M42 Junction 6 Development Consent Order (TR010027) - Non-material change request

Change 1: Proposed change to the southern extent of the Limit of Deviation for Work No. 63 (Severn Trent Aqueduct)

Change 2: Attenuation Tank Relocation (Work No. 34)

Drawing Title  
**FIGURE 3.7 SEVERN TRENT WATER AQUEDUCT PROTECTION AND DIVERSION SHEET 1 OF 2**

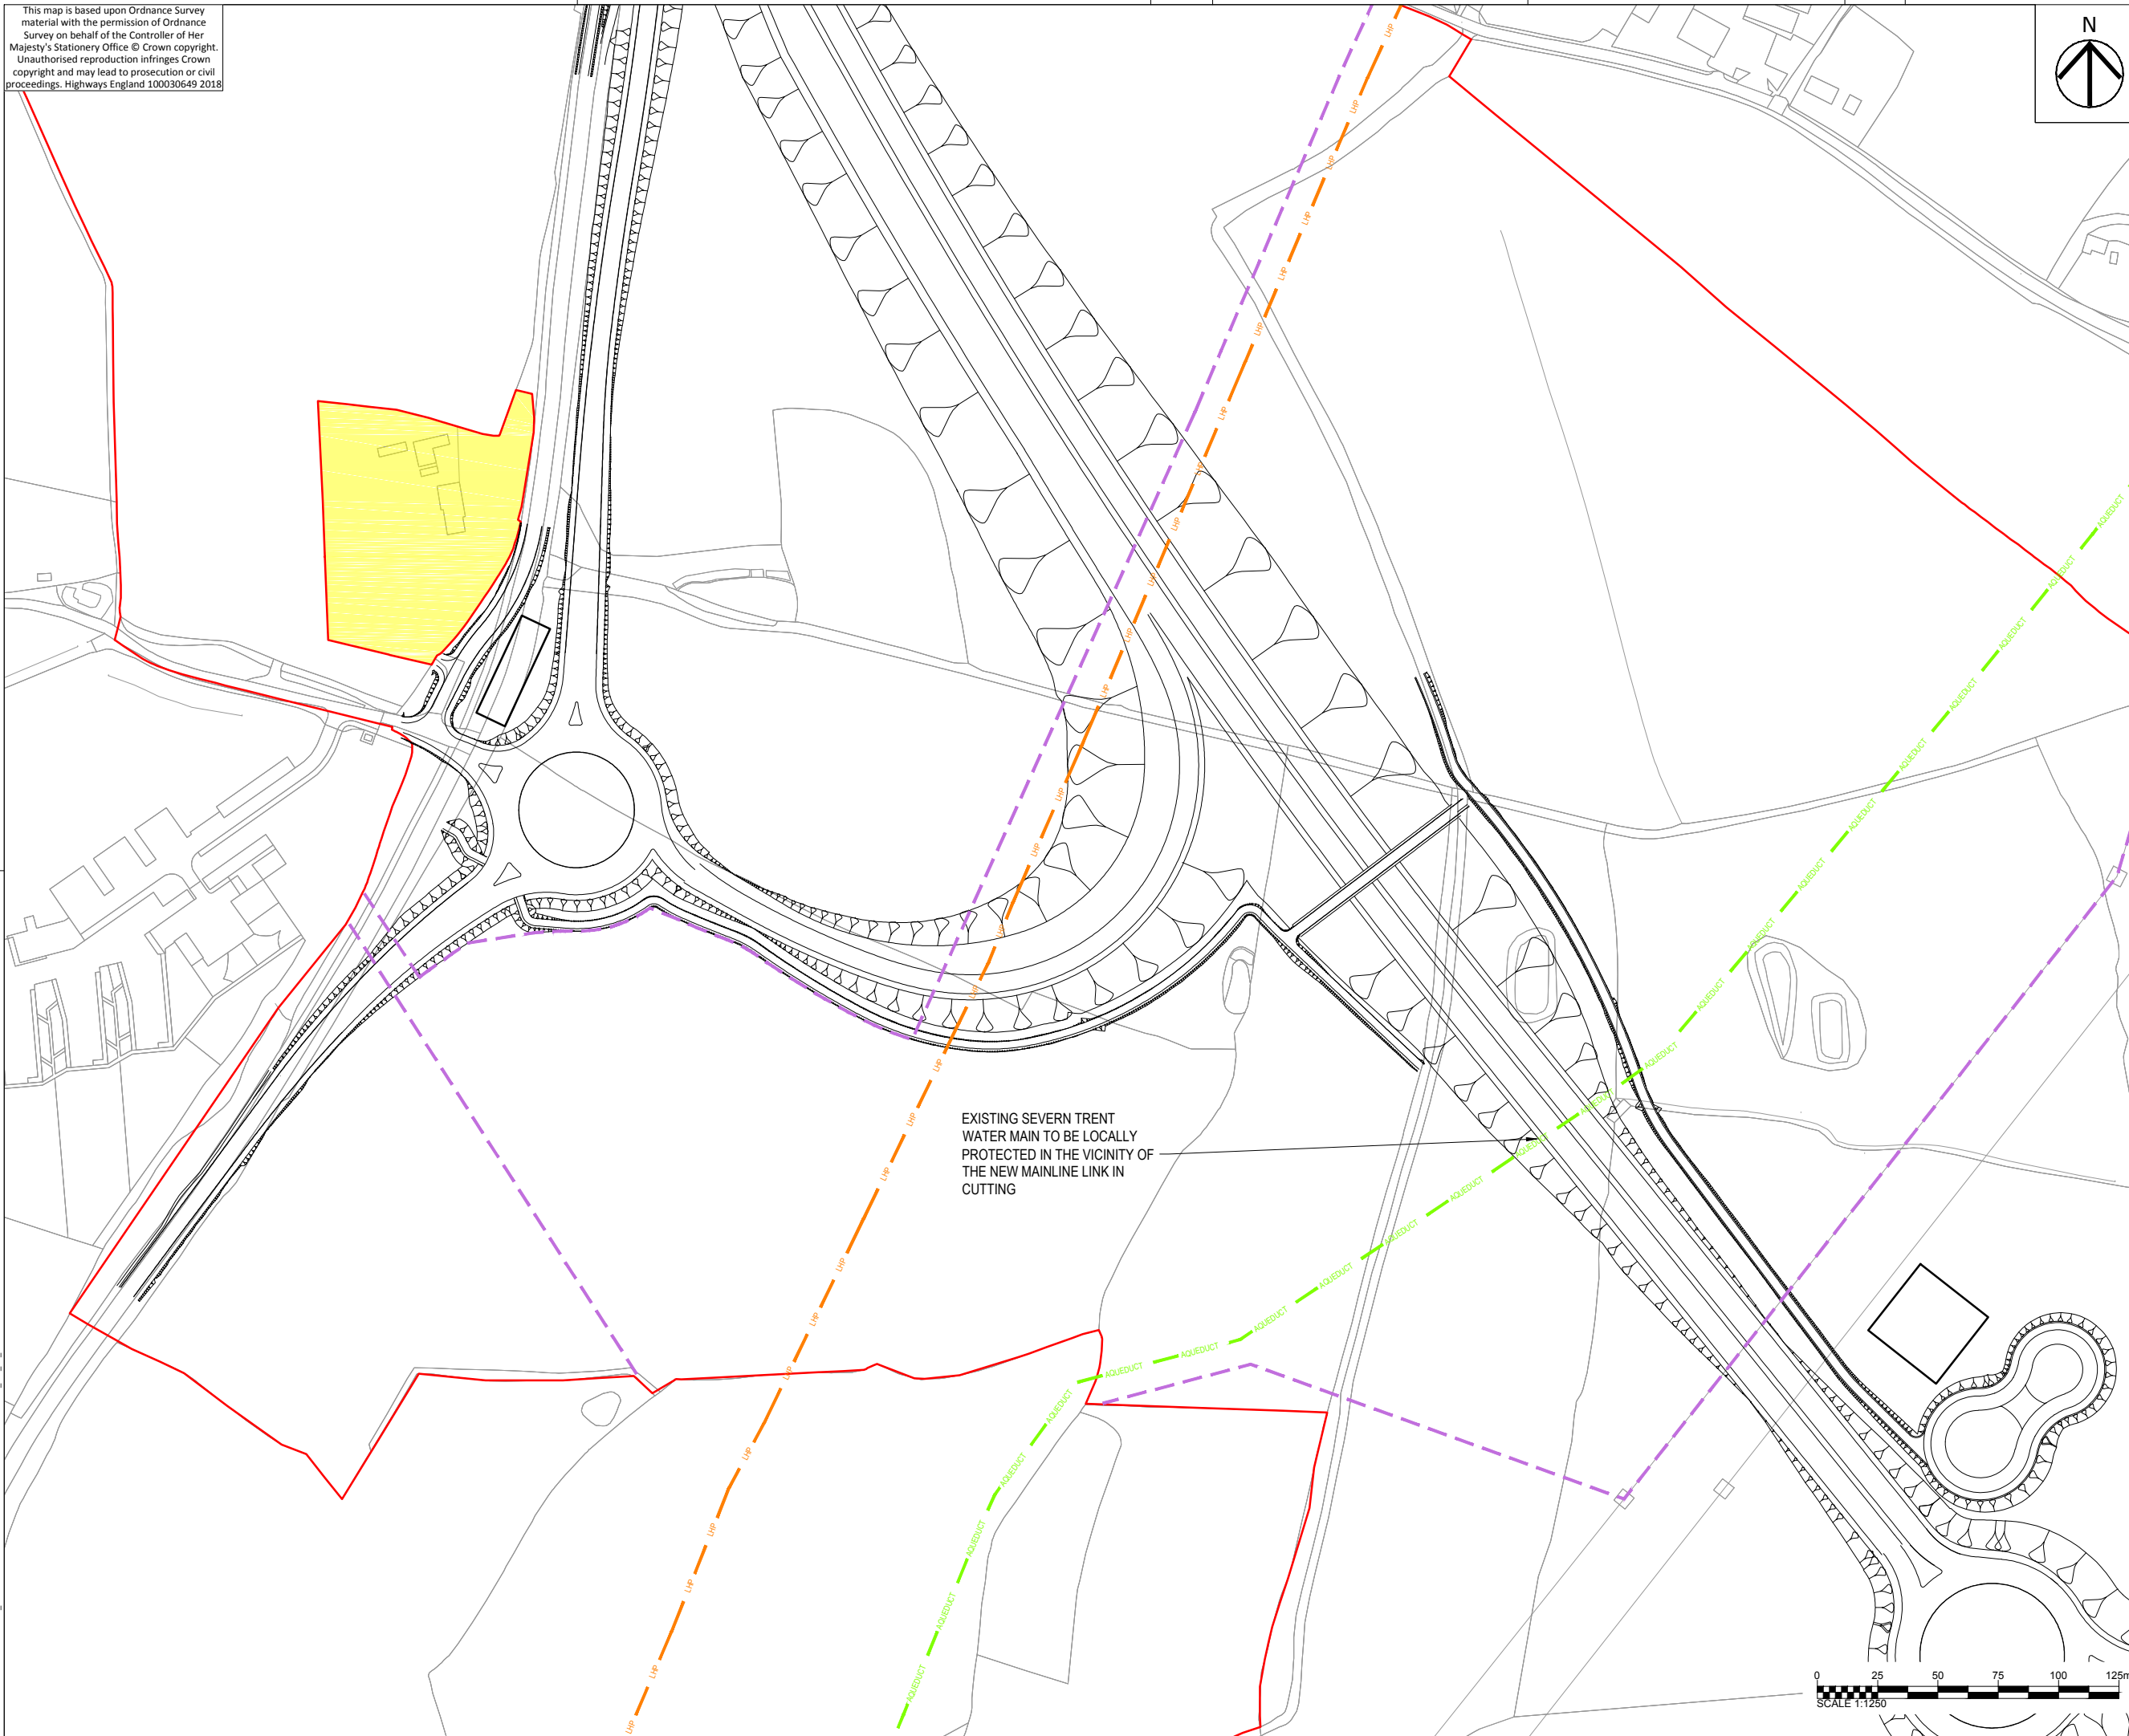
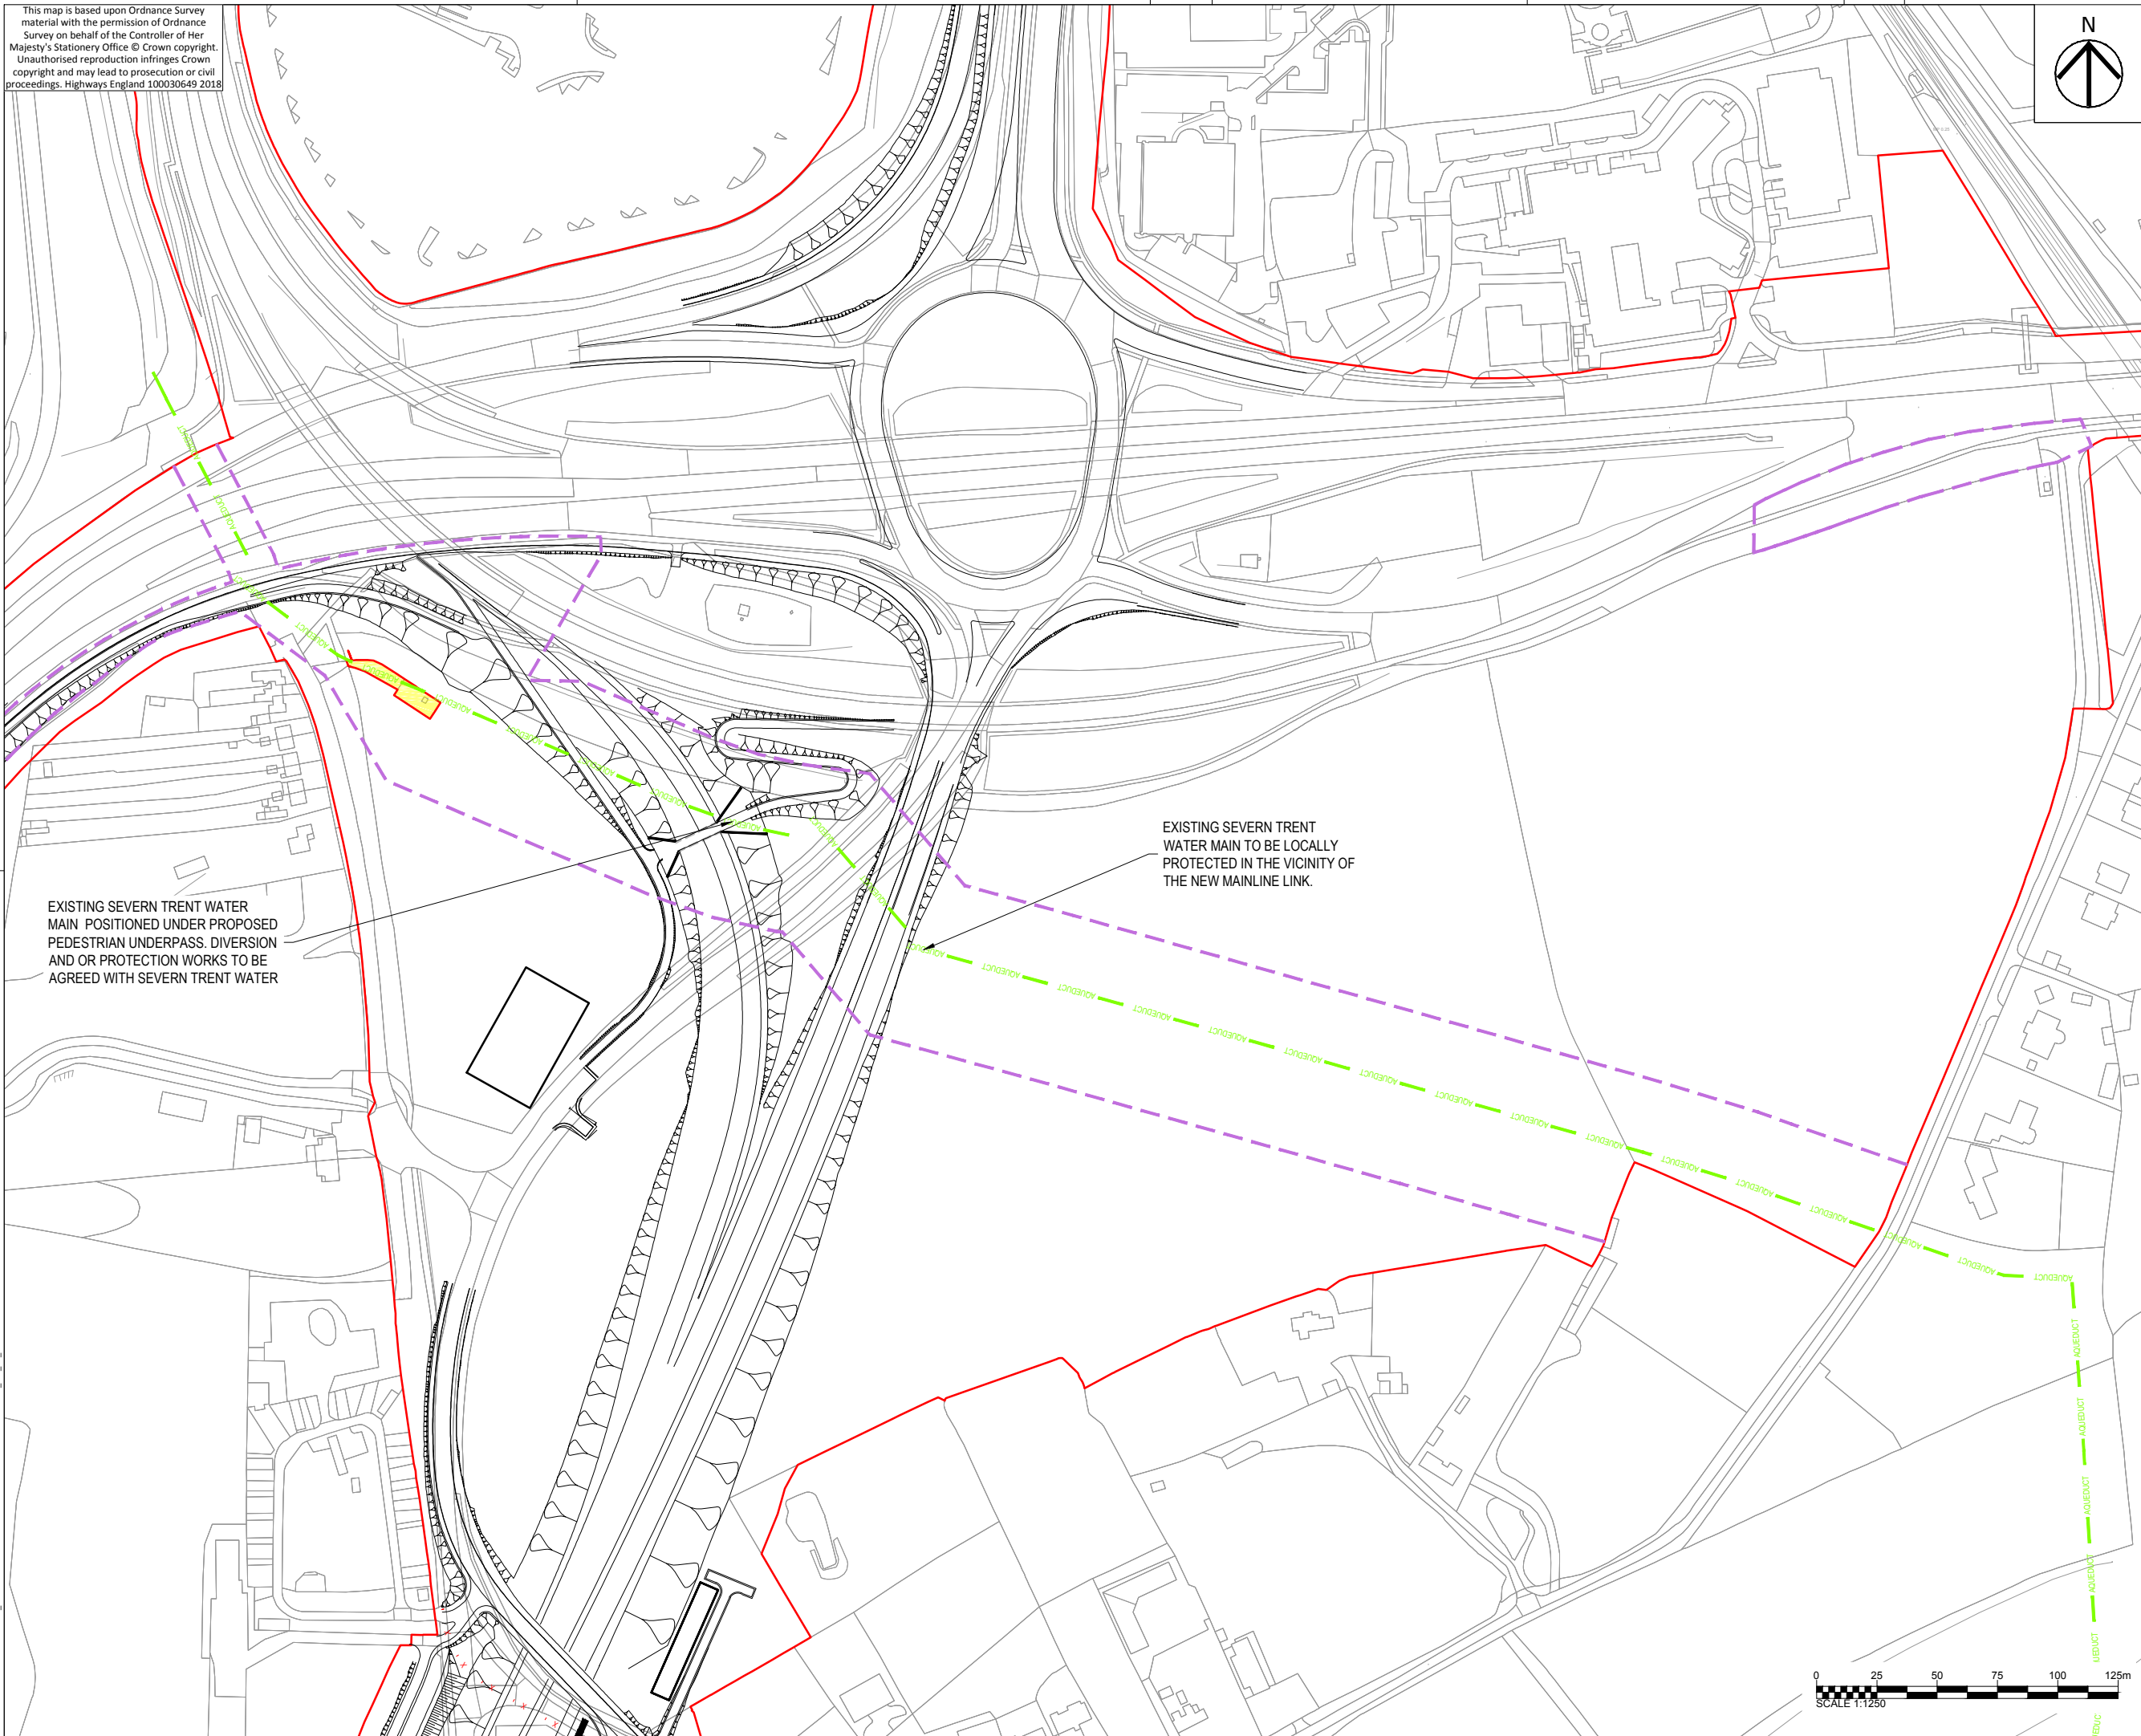
Design information provided by STW (see **Appendix A**) shows that its preferred route for the aqueduct diversion (Work No. 63) would be further south than that envisaged in the Scheme to allow greater ease of maintenance once the Scheme is operational.

This would necessitate the southern extent of the Limit of Deviation (LoD) for Work No. 63 (see **Appendix B**) to move further south from parcel 4/4w, into parcel 4/4k (see **Appendix C**). Both parcels have the same landowner. Parcel 4/4k is already proposed to be used temporarily for the diversion of Western Power Distribution's apparatus, with permanent rights being sought under the DCO "*to construct, operate, access and maintain diversions to existing utilities apparatus and equipment*" [**APP-018 / Volume 4.1**].

Although STW is a statutory utility, and so the diversion is already covered by the wording of Schedule 7, the Applicant proposes to alter this description of this right in the dDCO so that it refers explicitly to Work No. 63 as well.
